RE: Lookout Large Lot (LL-08-03)

The Kittitas County Community Development Services Department has determined that the Lookout Large Lot (LL-08-03) is a complete application and hereby grants **conditional preliminary approval** subject to the following conditions:

TO: Trudie Pettit, Community Development Services
FROM: Randy Carbary, Planner II *RC*
DATE: May 7, 2008
SUBJECT: Lookout Large Lot Subdivision 08-03

OWN BY	DATE	JOB NO.
DP/ST/GW	03/2008	08009
CHKD BY	SCALE	SHEET
D. NELSON	1"=500'	1 OF 3

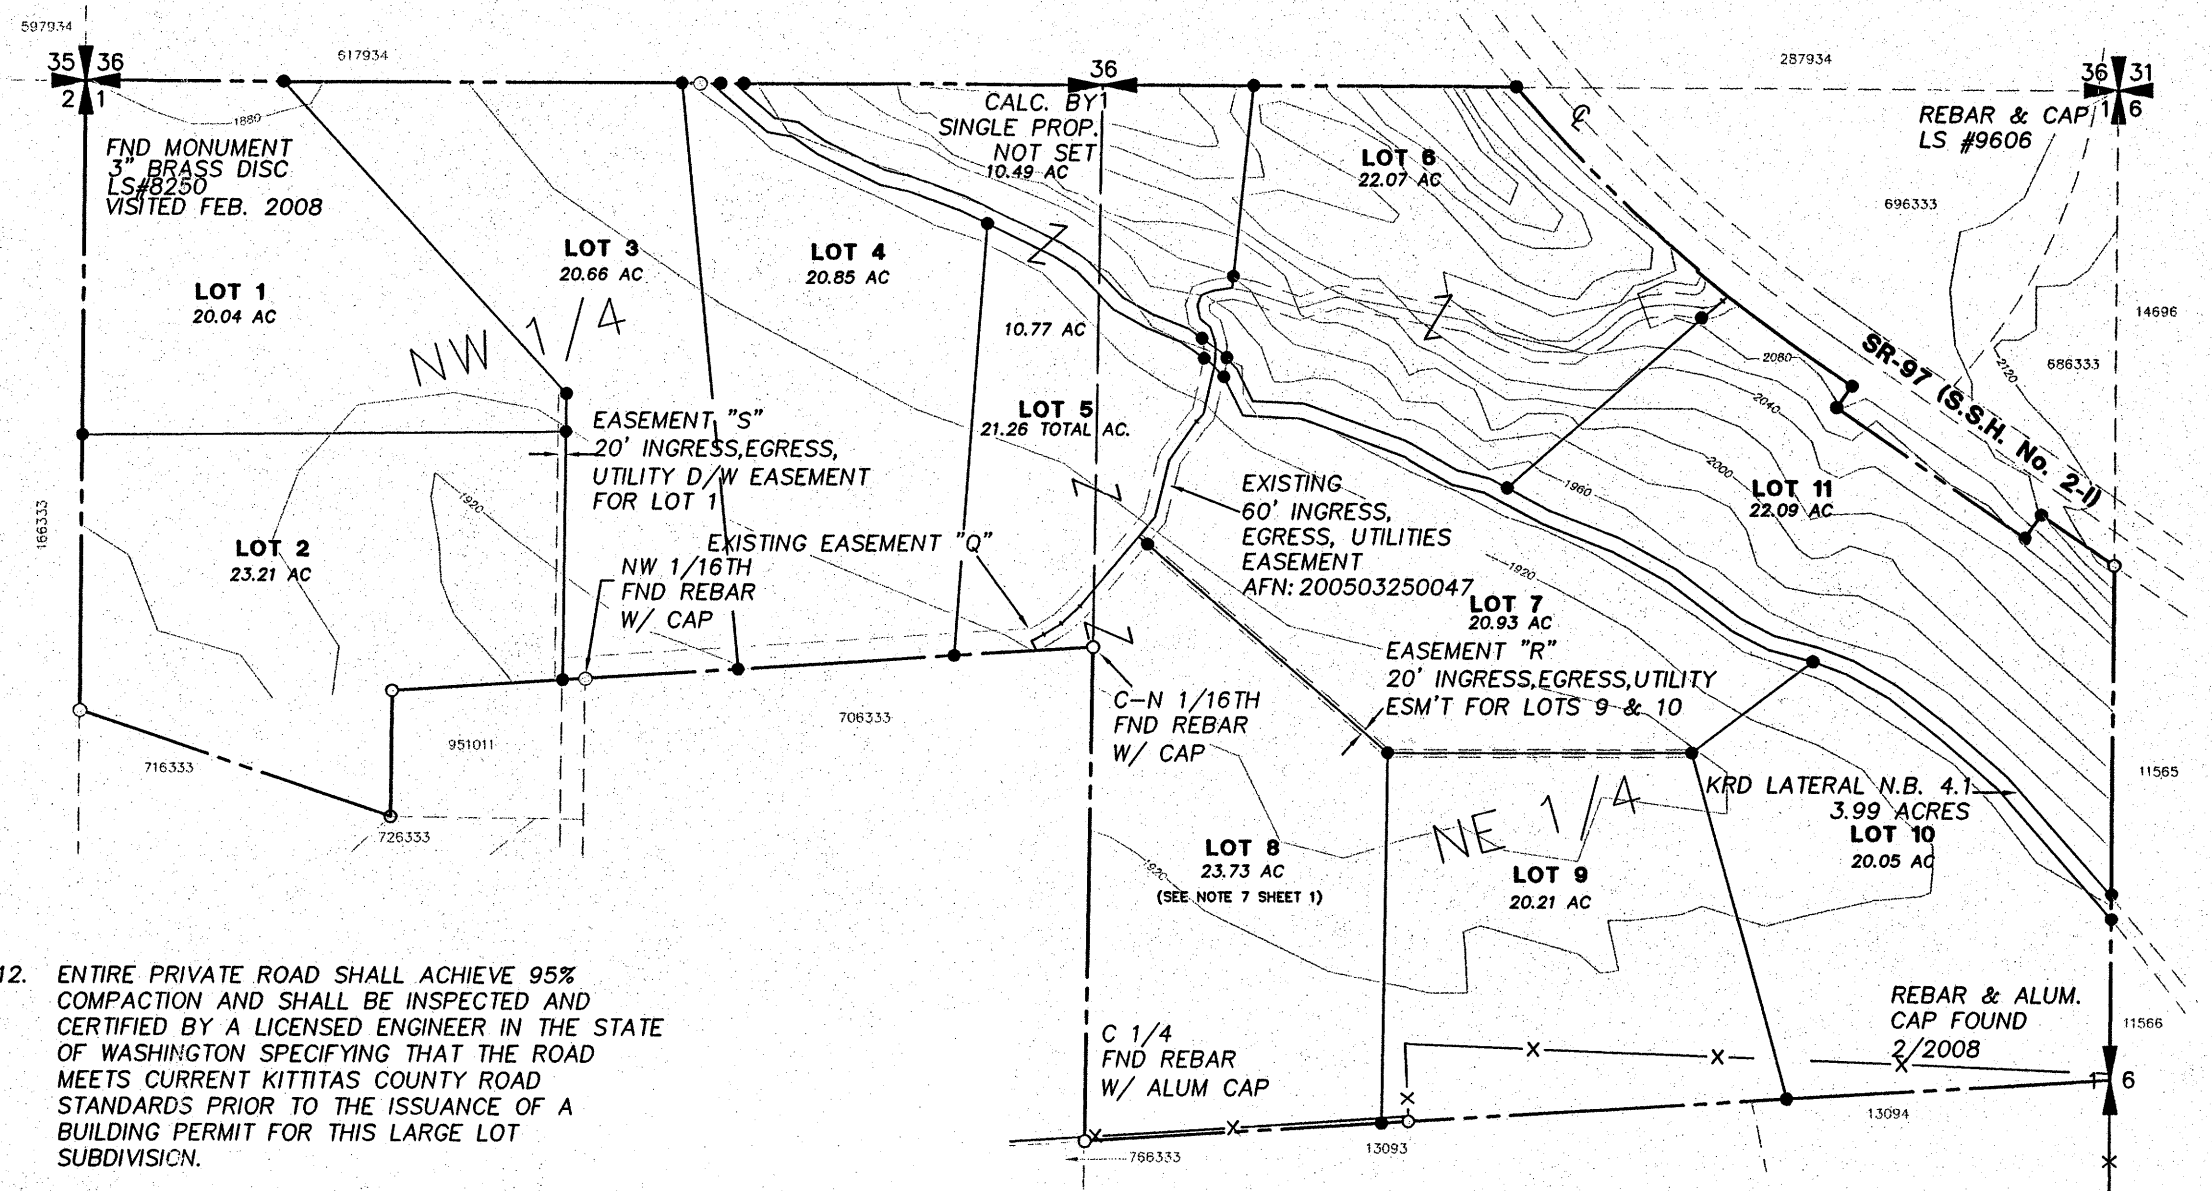
3. Contours: Sheet 1 of 3 shows contours, however, the intervals used are not easily read at the scale provided and do not provide enough detail for an effective review of the

application. The applicant shall provide updated contour information with the appropriate intervals, as required by KCC16.12.030 Existing conditions.

- A. *Contour lines at intervals of five feet for slopes less than thirty percent, and ten feet for slopes over thirty percent at preliminary review only , or the use of USGS maps to represent elevations and slopes at preliminary review may be used and where such maps are utilized at preliminary review they must be verified by Contour lines of five feet for slopes less than thirty percent and ten feet for slopes over thirty percent at final review.*
